From: Julie Grieves on behalf of Planning.Responses
Sent: 05 April 2019 11:01
To: Planning Scanning
Subject: FW: Planning Consultation on AL/20/19/DOC

Site Layout with Proposed Add'l Hard Surfaced Parking Area

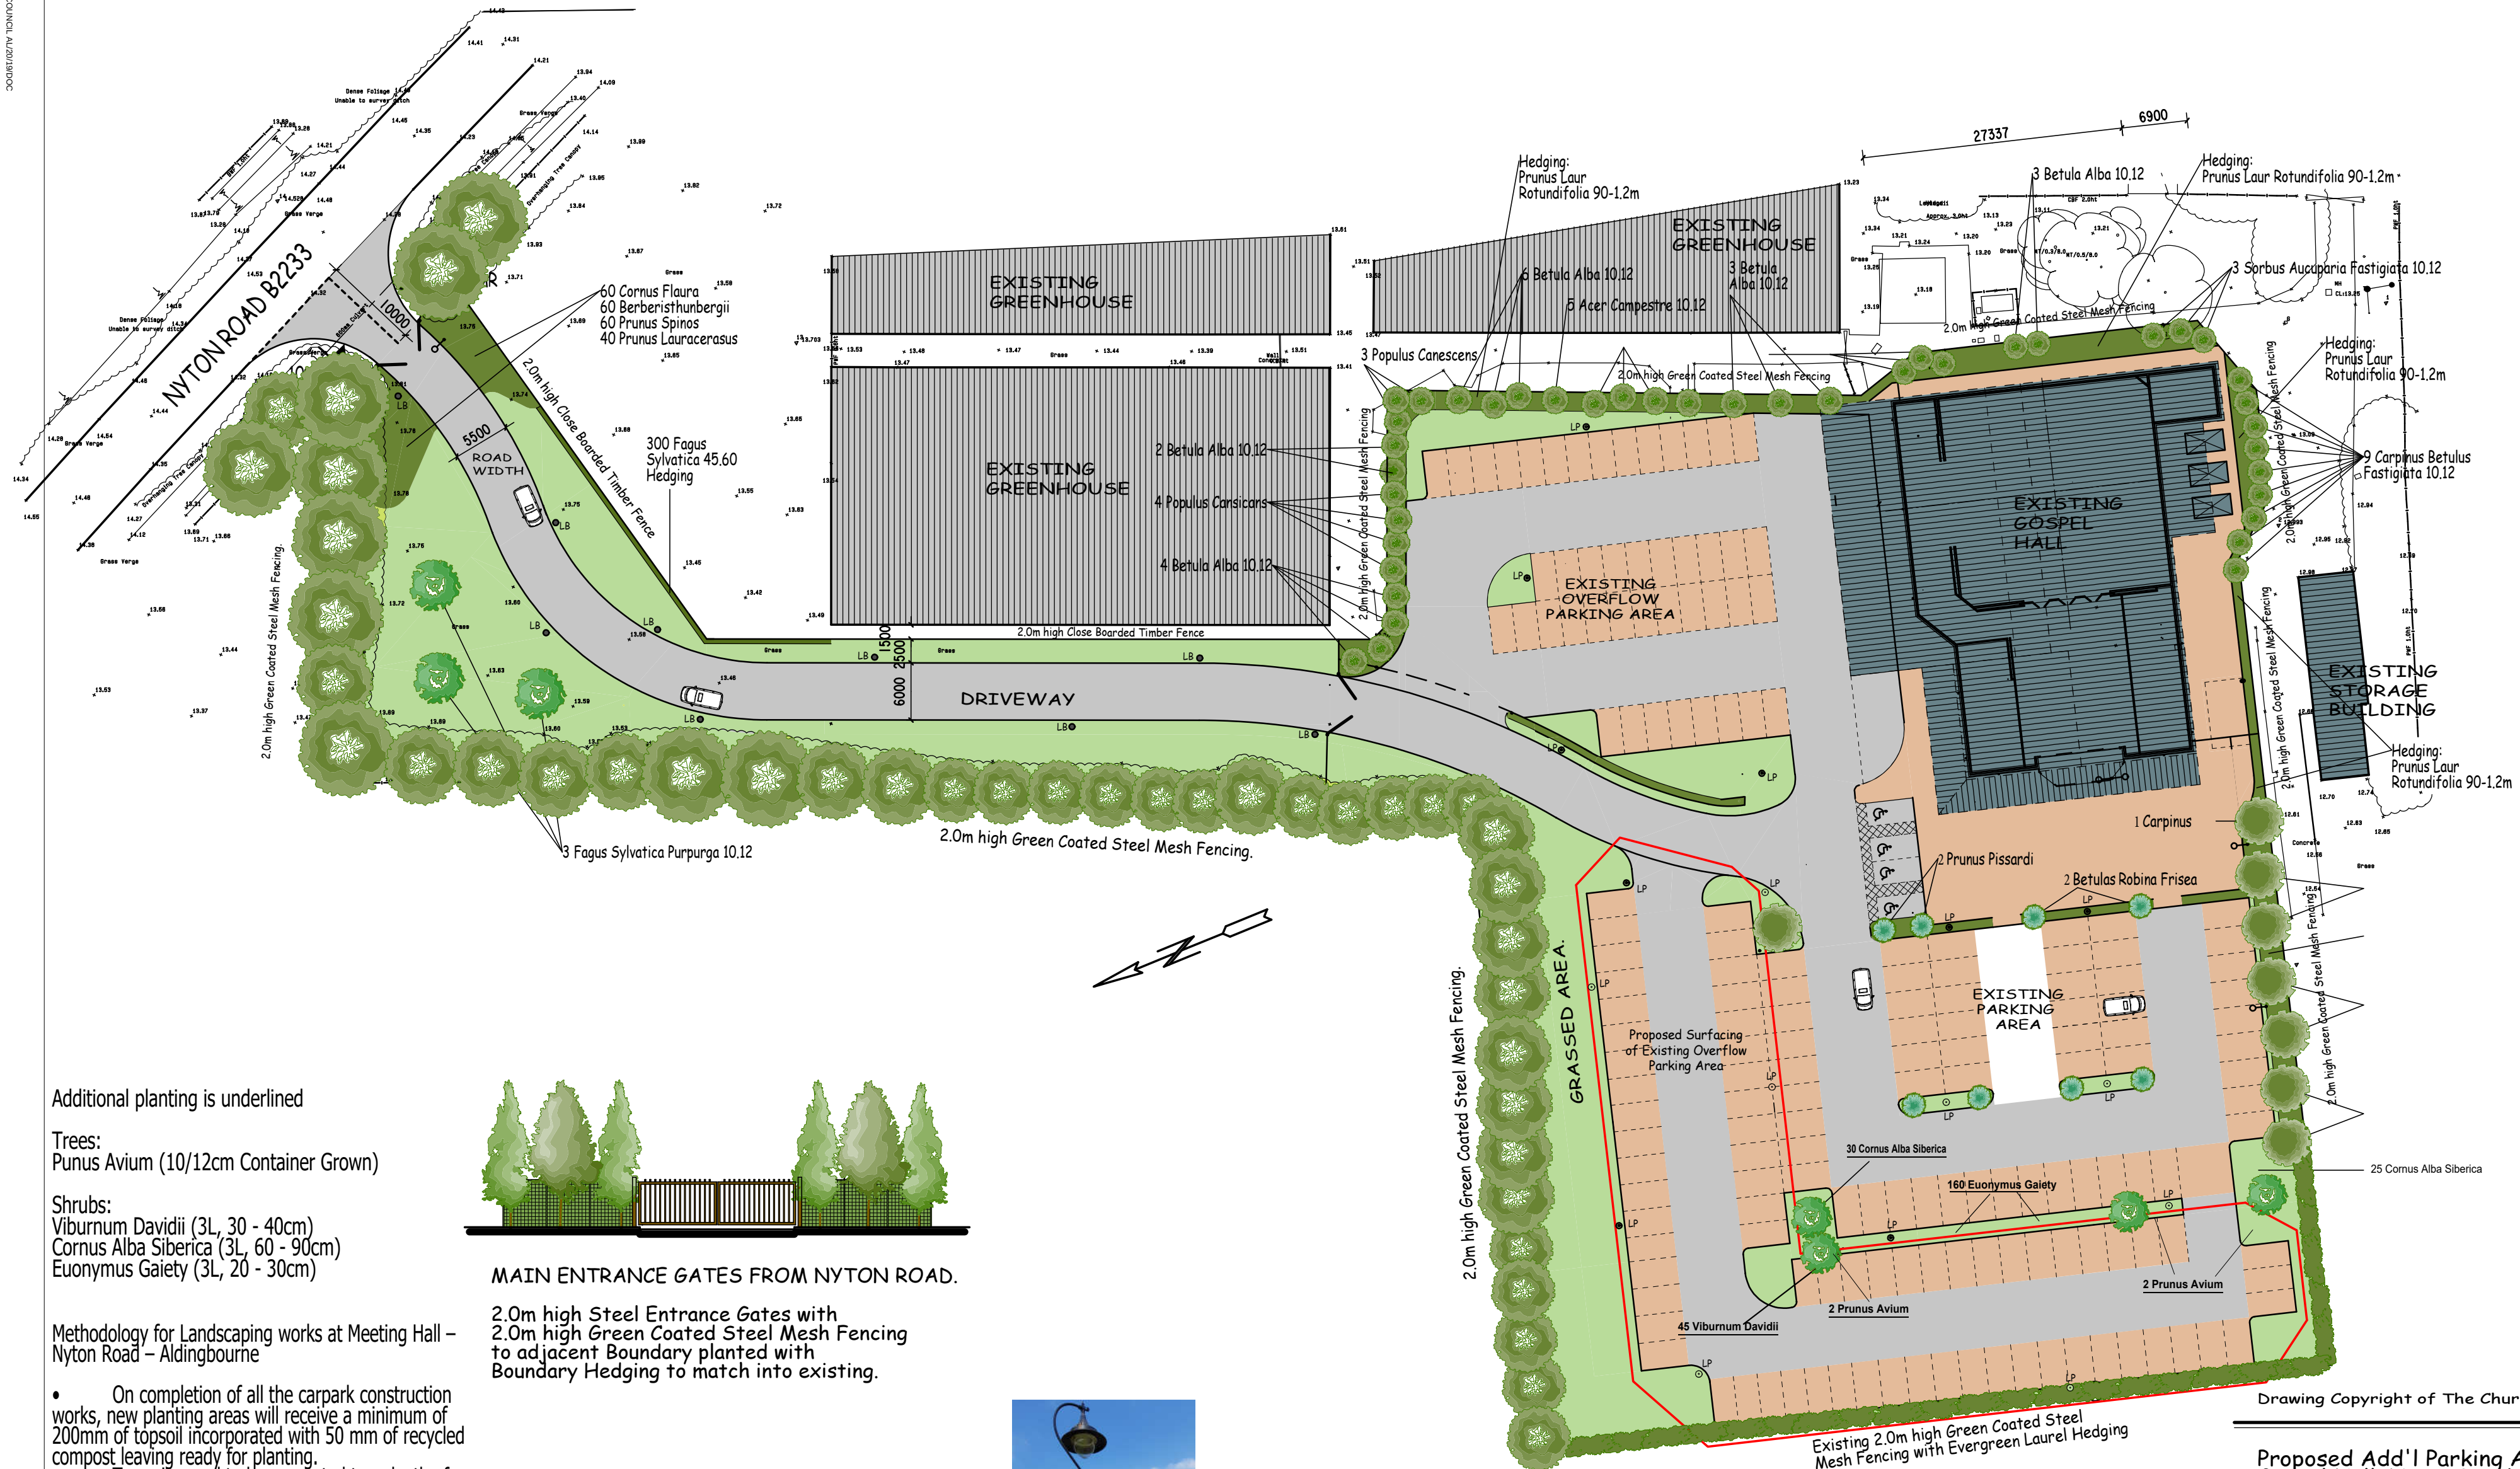
I just given Robin at Luken Beck a call as the drawing is missing quantities; which he responded "I thought you would need those"

No issue he is going to get these added to the plan and sent through, then should be fine to recommend discharge of condition 4.

Please find an amended landscape plan attached, which hopefully meets your Landscape Officer's requirements.
